PROPOSED MULTI-FAMILY PROJECT
 HWY 51
 CHARLOTTE, N. CAROLINA

CHARLOTTE-MECKLENBURG PLANNING COMMISSION
INTER-OFFICE COMMUNICATION

DATE: August 17, 1995
 TO: Robert Brandon, Zoning Administrator
 FROM: Martin R. Cramton, Jr., Planning Director
 SUBJECT: Administrative Approval for Petition No. 94-14(c) by Brock Consulting Group Inc., Tax Parcel No. 213-051-08

DRAWING TITLE
TECHNICAL DATA SHEET

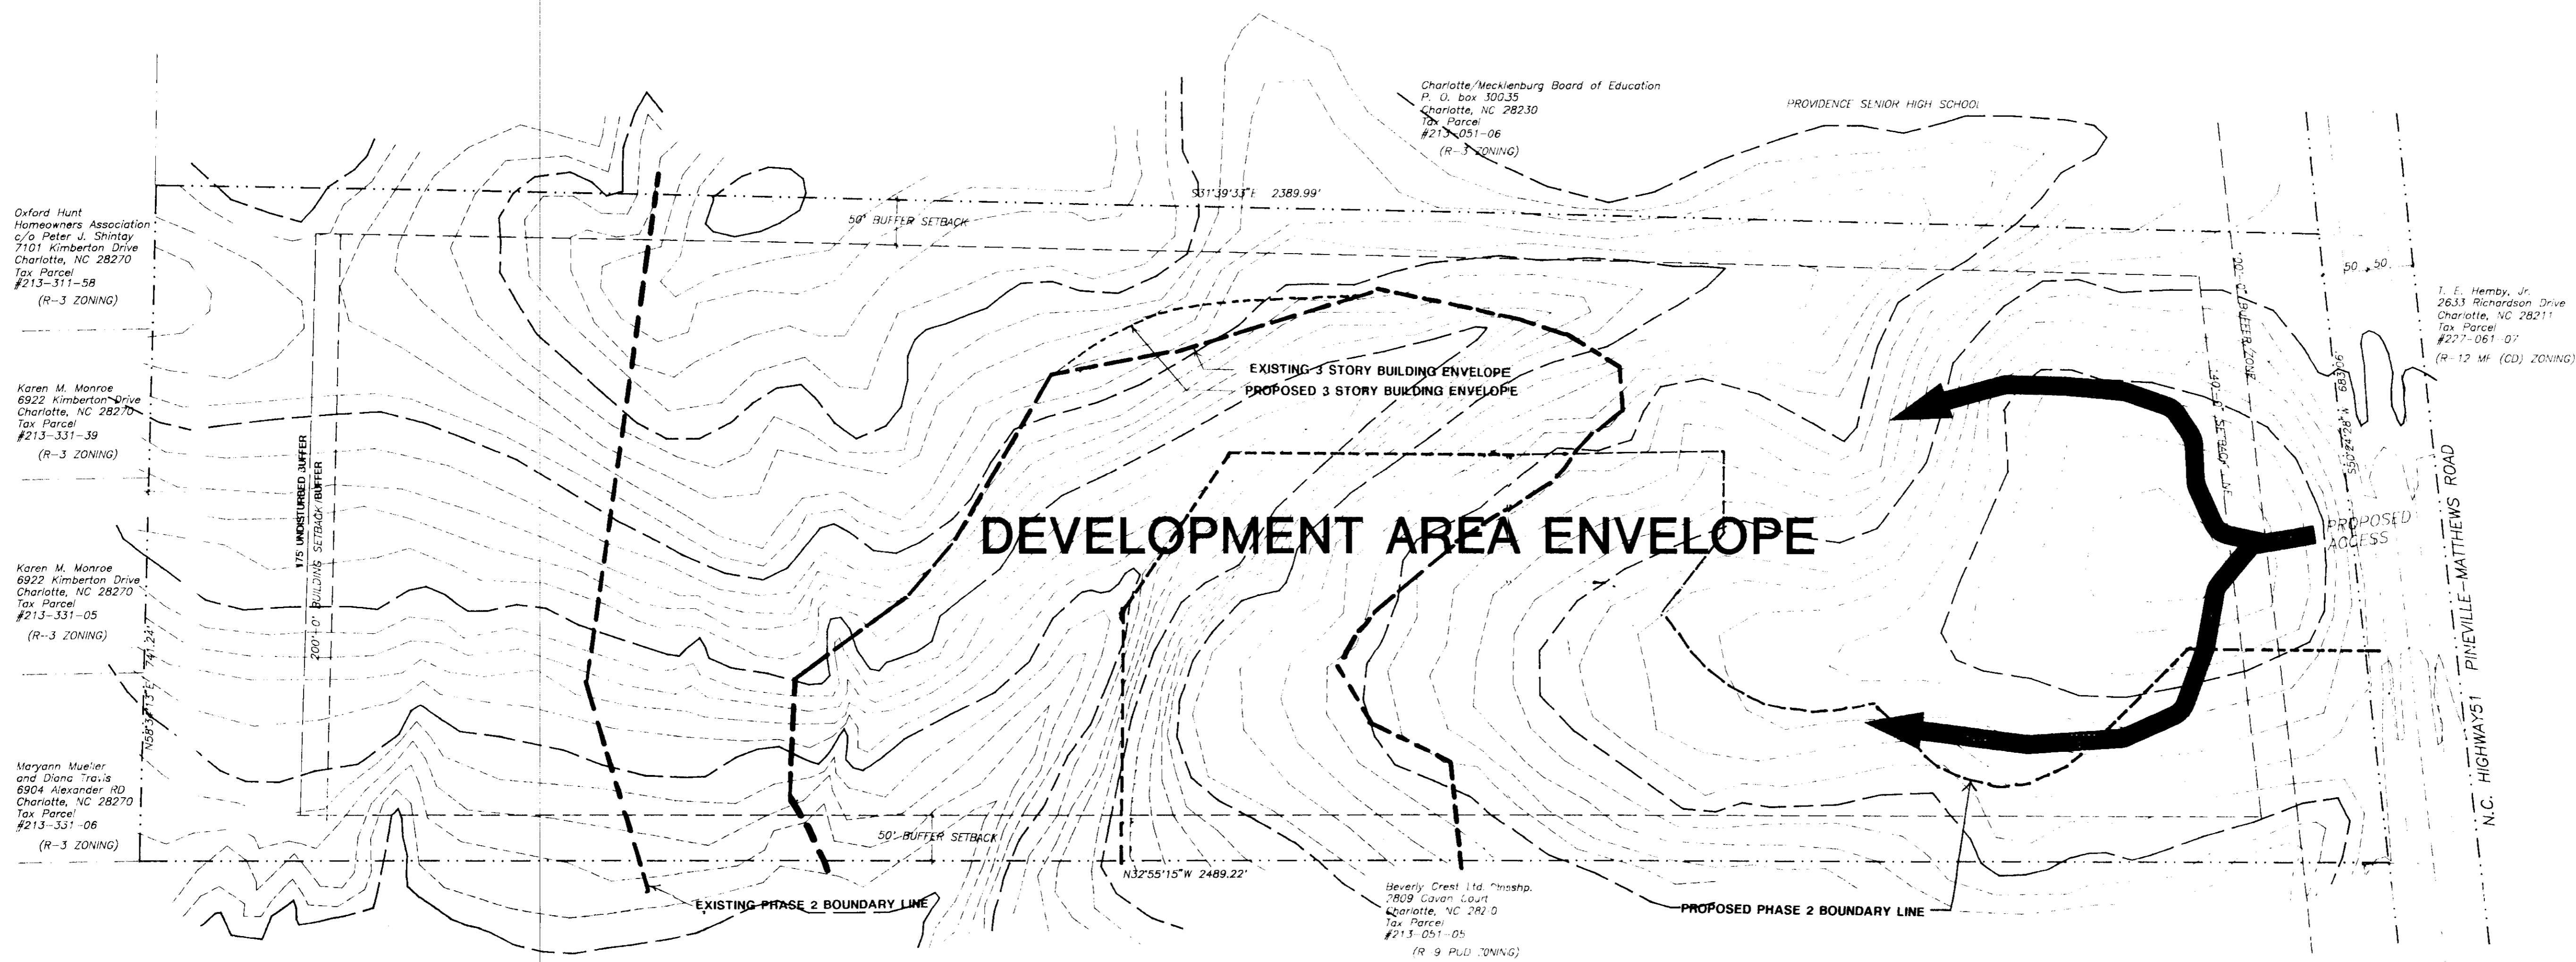
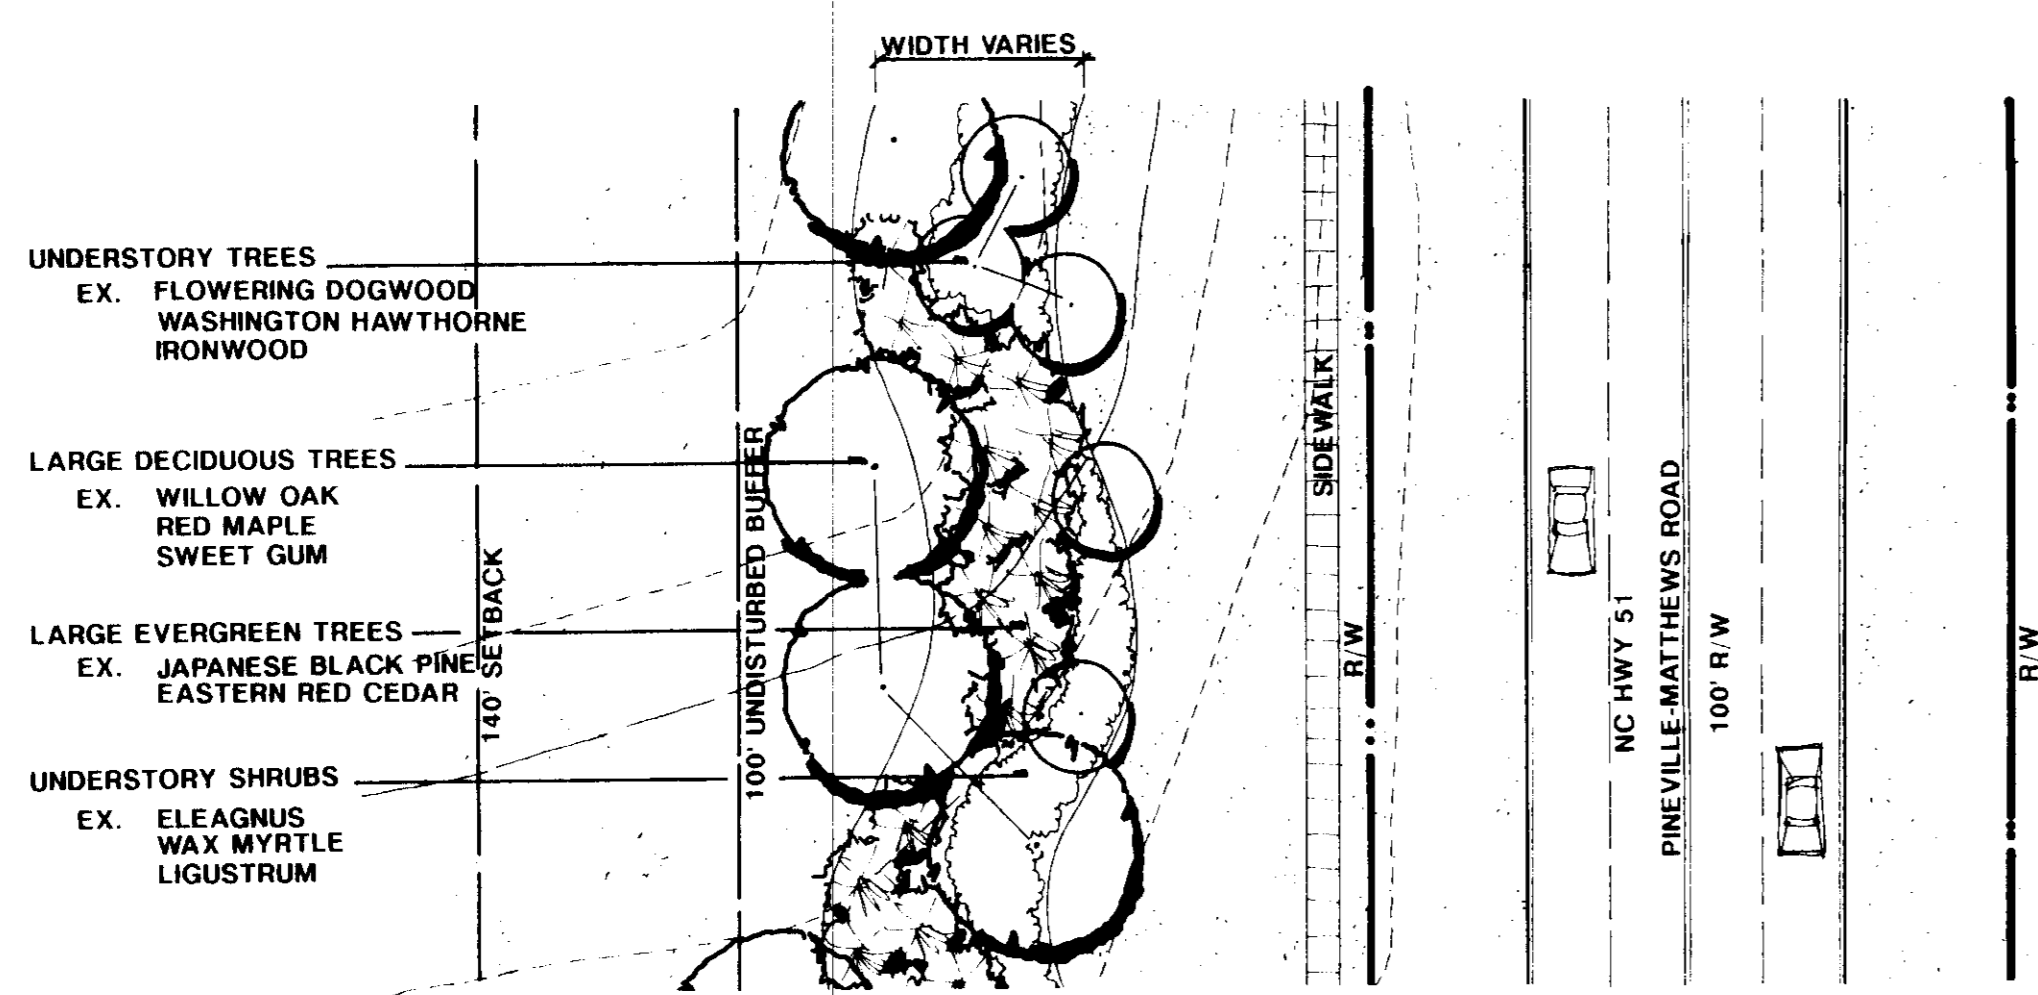
- Show a Phase 2 construction entrance independent of the primary project entrance.
 - Increase site coverage (buildings, driveways, and parking) from 596,391 sf (34.23%) to 615,753 sf (35.34%).

- To reduce open space from 65.77% to 46.56%.
 - To slightly adjust the 3 story building envelope line to accommodate (6) 3/2 split buildings 9, 10, 11, 25, 26, 27.

DRAWING TITLE
CONCEPTUAL PLAN

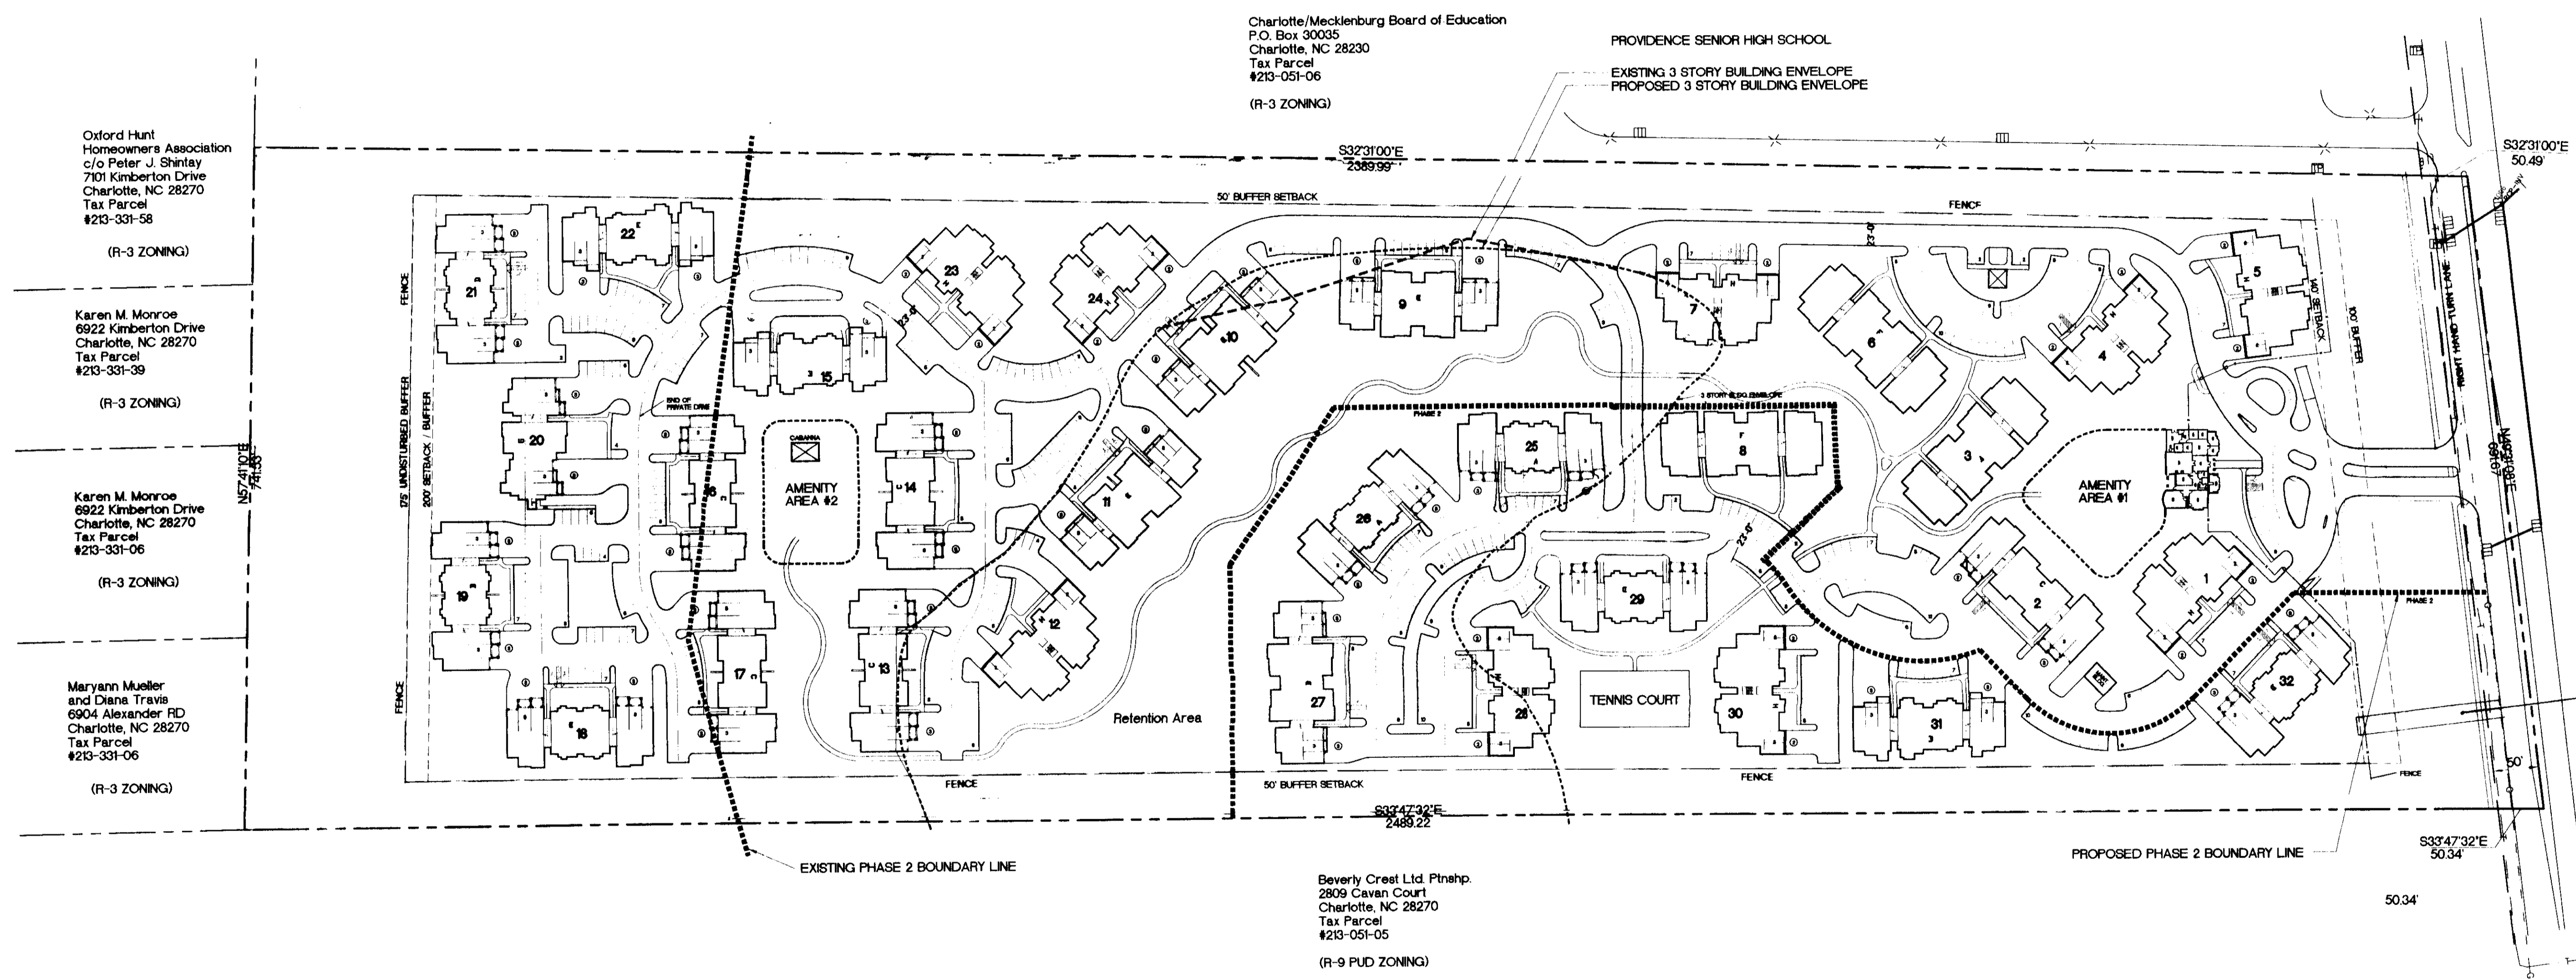
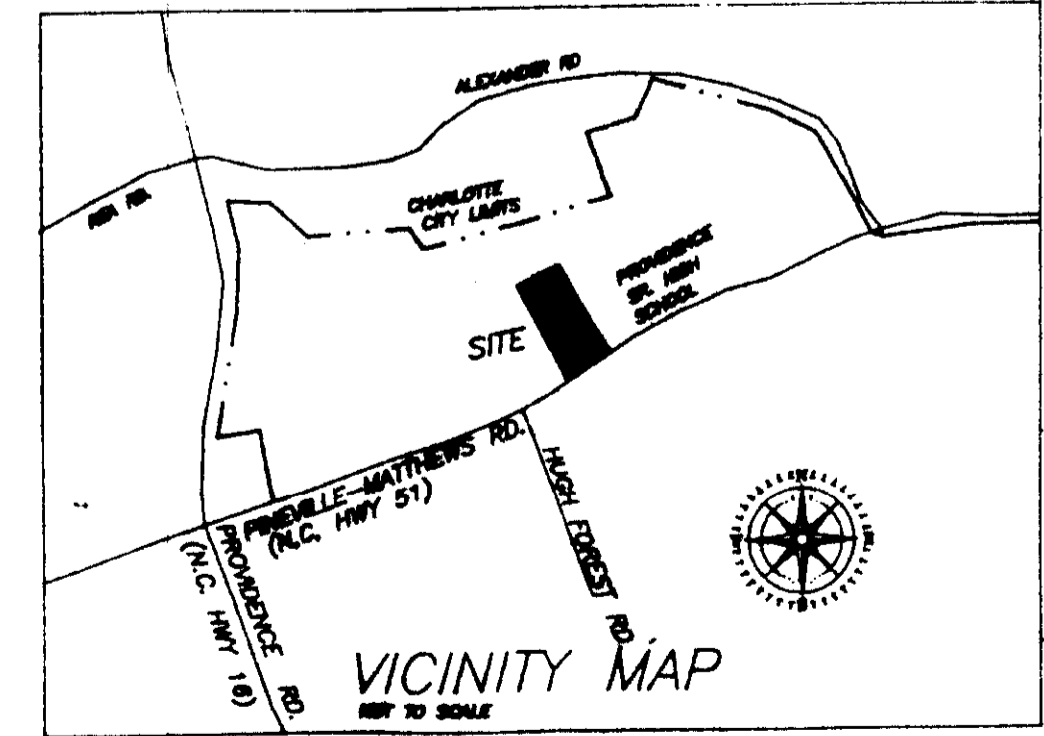
- Attached is a revised site plan for the above referenced rezoning petition. This site plan has been revised to:
- Adjust the Phase 2 boundary line from the north edge of the property to the southwest quadrant. Phasing of units will include 292 in Phase 1 and 128 in Phase 2.

- To reduce the minimum fire lane width from 24'-0" to 23'-0" based upon verbal approval by the City of Charlotte Fire Department.
- Since these changes are minor and the intent of the originally approved plan has been met in this revised site plan then I am approving these changes administratively. Please use this revised site plan when evaluating requests for building permits and certificates of occupancy.
